Please see comments below from Council's Infrastructure Team in relation to Huntlee Mod. 17.

Figure 4 | Proposed modifications

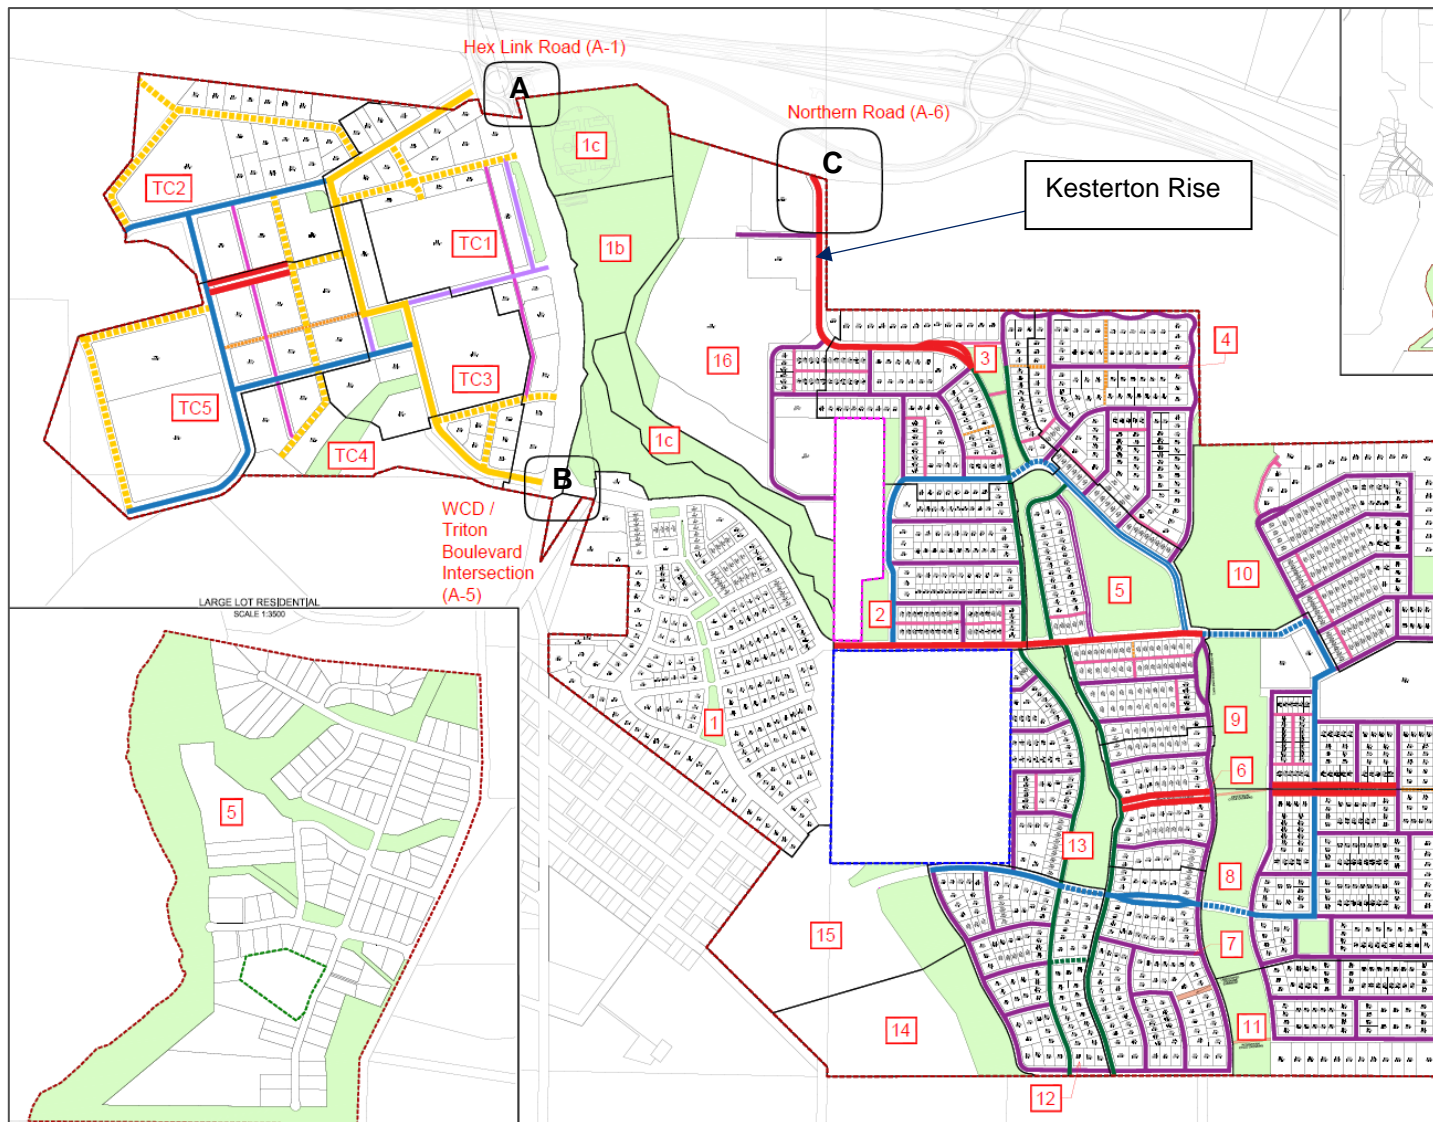
The trip distribution diagrams indicate there is expected to be 309 veh/hr turning left out in the morning peak hour (230 veh/hr of which would then u-turn at the roundabout). The Guide to Traffic Management Part 6 (Austroads, 2019, p.51) indicates an acceleration lane would be appropriate where turning volumes are high (eg. 300-500 veh/hr). So, if possible within the planning framework and environmental factors, it would be beneficial to have an acceleration lane included in the design of that intersection for vehicles turning left out.

At a normal T-junction, vehicles turning right from the major road into the side street have priority over vehicles turning right out of the terminating road. However, at this intersection there is a give way holding line across the right turn bay on Wine Country Drive (south) which makes the priority of this movement confusing (see attached aerial photo). My understanding of the road rules (extract attached) is that both right turners from Wine Country Drive (south) and from Triton Boulevard both have to give way to each other, which doesn't help clarify the actions drivers are expected to take.

Given the priority allocation of a normal T-junction where main road movements dominate side road movements, the priority confusion described above will be exacerbated by the high volume of vehicles turning right out of Triton Boulevard compared with the volume of vehicles expected to turn right from Wine Country Drive into Triton Boulevard.

The proponent expects capacity to be satisfactory. However, for operational effectiveness (ie safety), it is suggested the priority control be made very clear. For example, by removing the give way holding line that exists across the right turn bay on Wine Country Drive (south).
